Our Ref: Y/18/20/PL
Your Ref:

Town & Country Planning Act 1990 (as amended)
Town and Country Planning (Development Management Procedure) (England) Order 2015
Application for Planning Permission

Development 6 No. residential dwellings & associated infrastructure. This application is a Departure from the Development Plan.

Location Land east of North End Road & West of Church Lane Nursery Yapton

3 BEDROOM
FRONT ELEVATION - North
Detached House
Plot 2

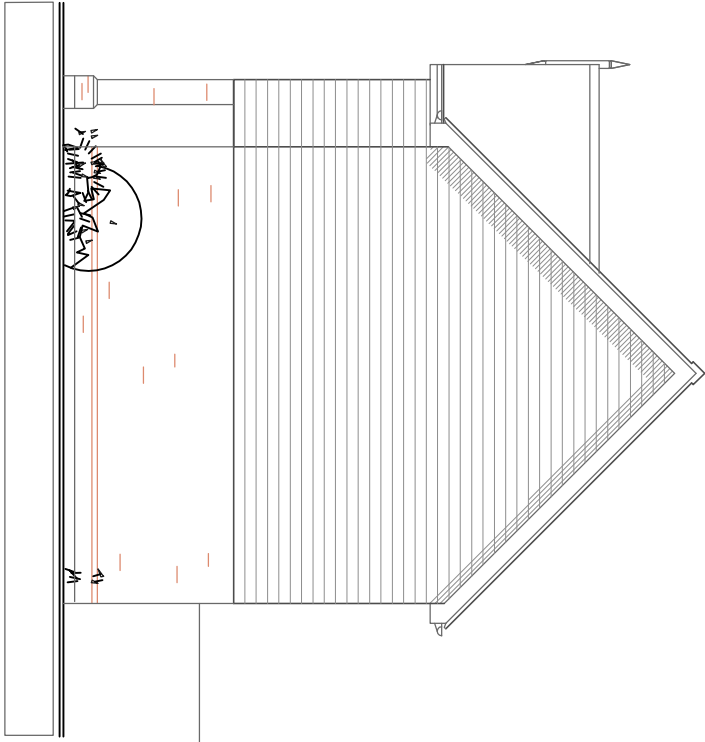
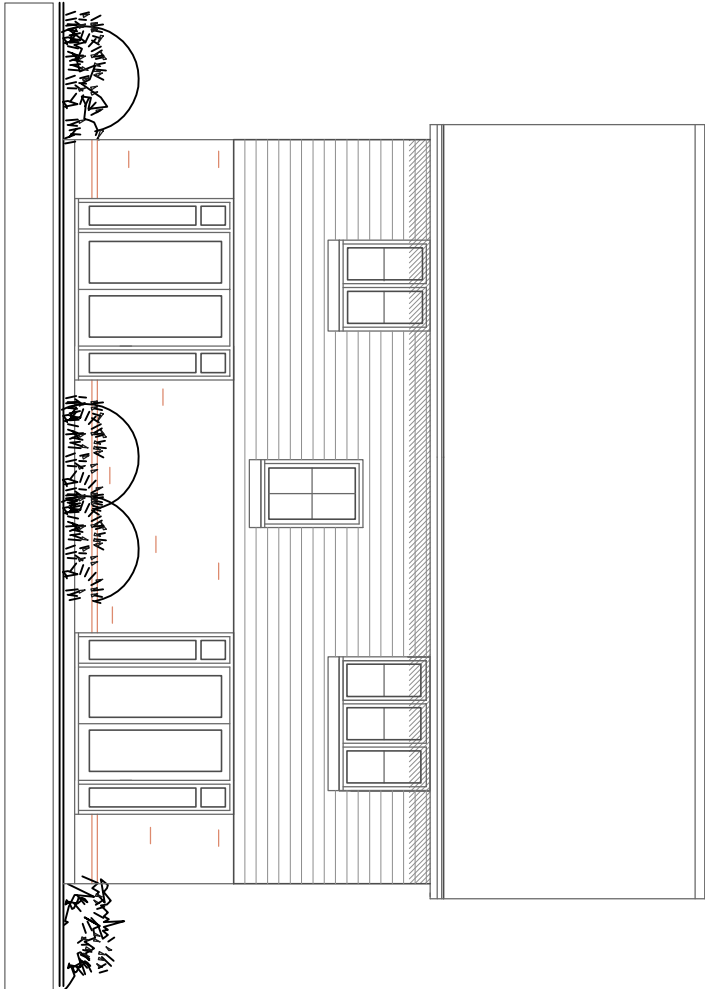
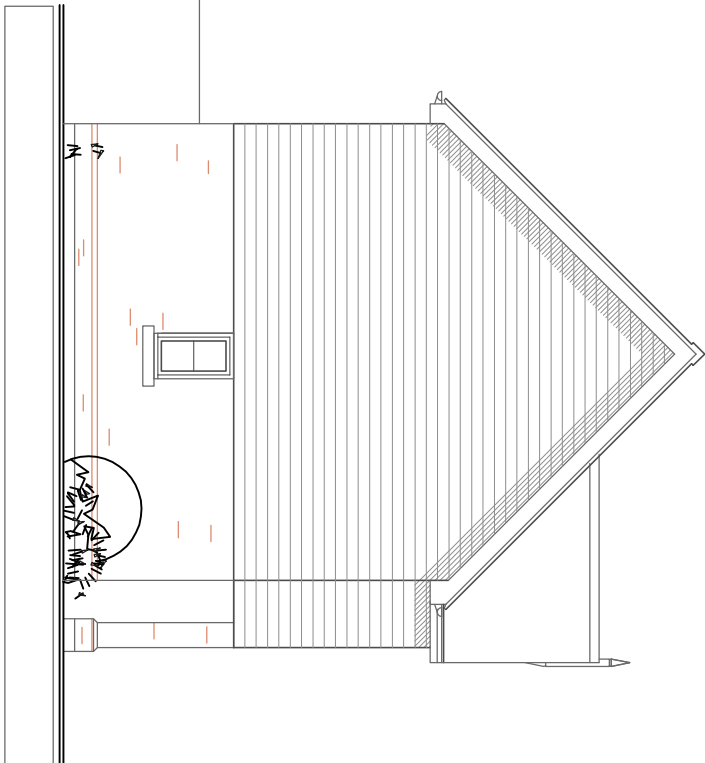
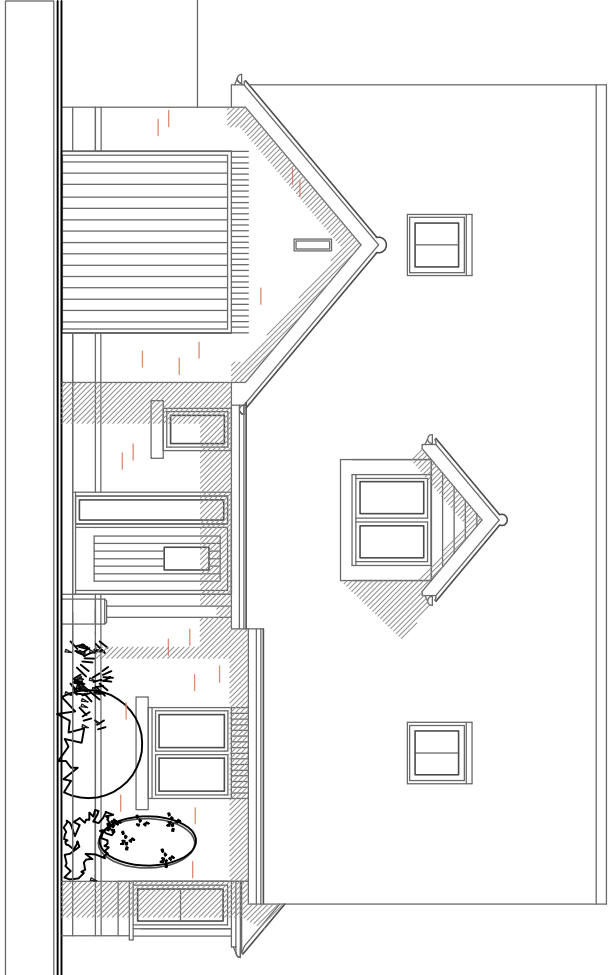
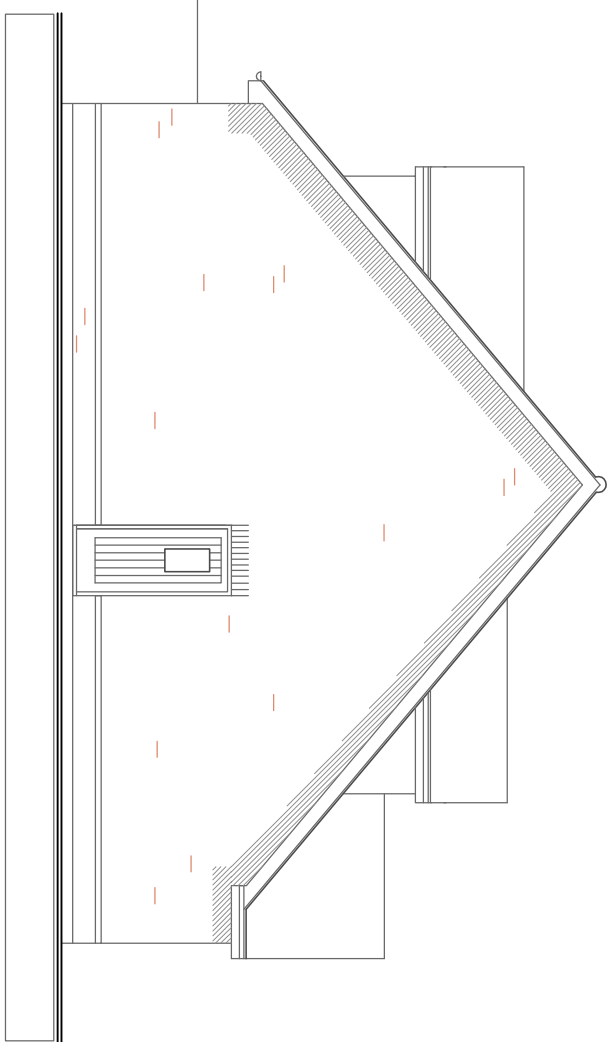
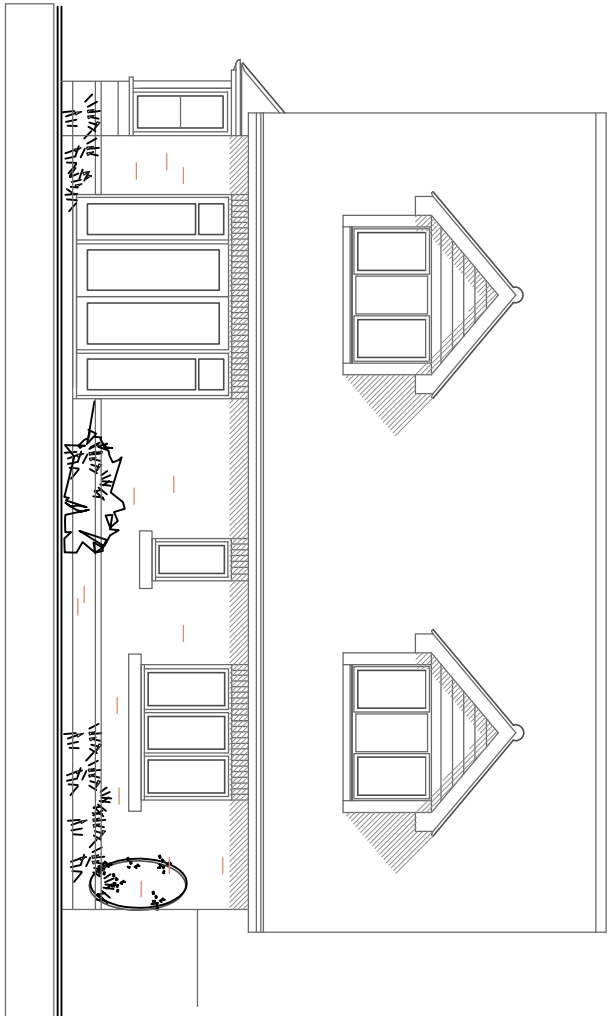
The east and west elevations have been mislabelled on plots 2 and 3. Please amend accordingly.
